**EL PASO COUNTY PLANNING AND
 COMMUNITY DEVELOPMENT
 DEPARTMENT**

STORMWATER MANAGEMENT PLAN CHECKLIST

VR2321

Vehicle Tracking Control (VTC) SM-4

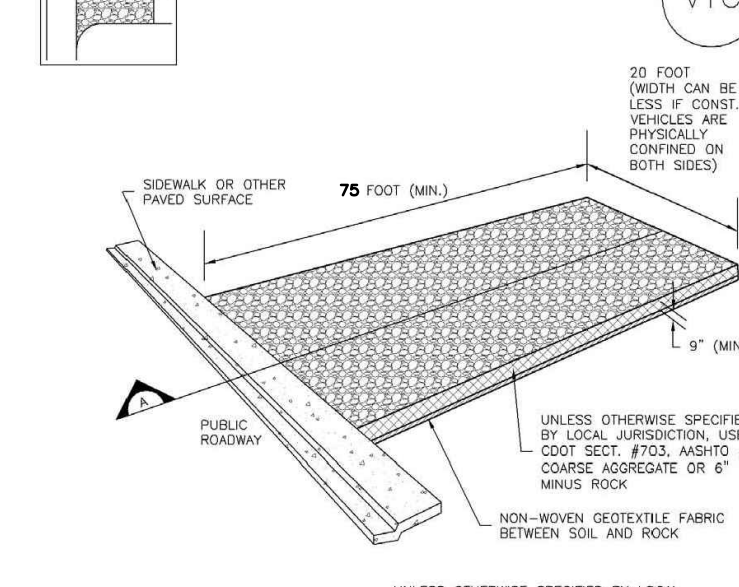
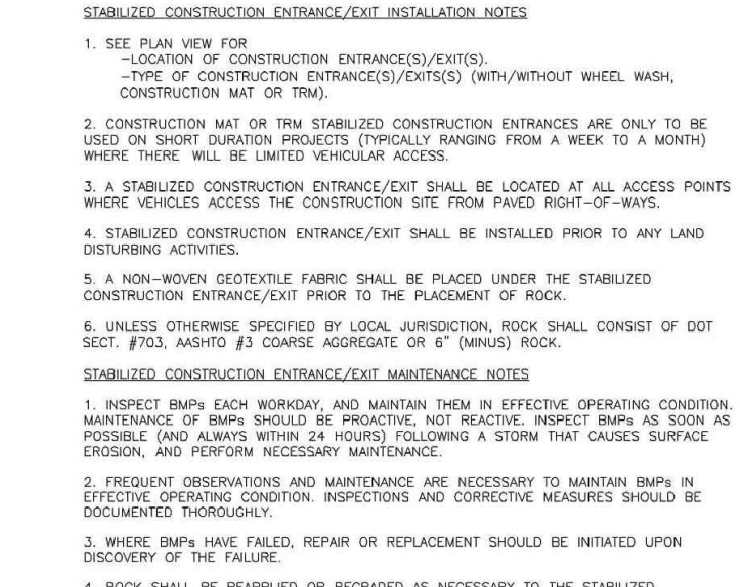
Revise VTC detail per my
 comment in GEC Plan
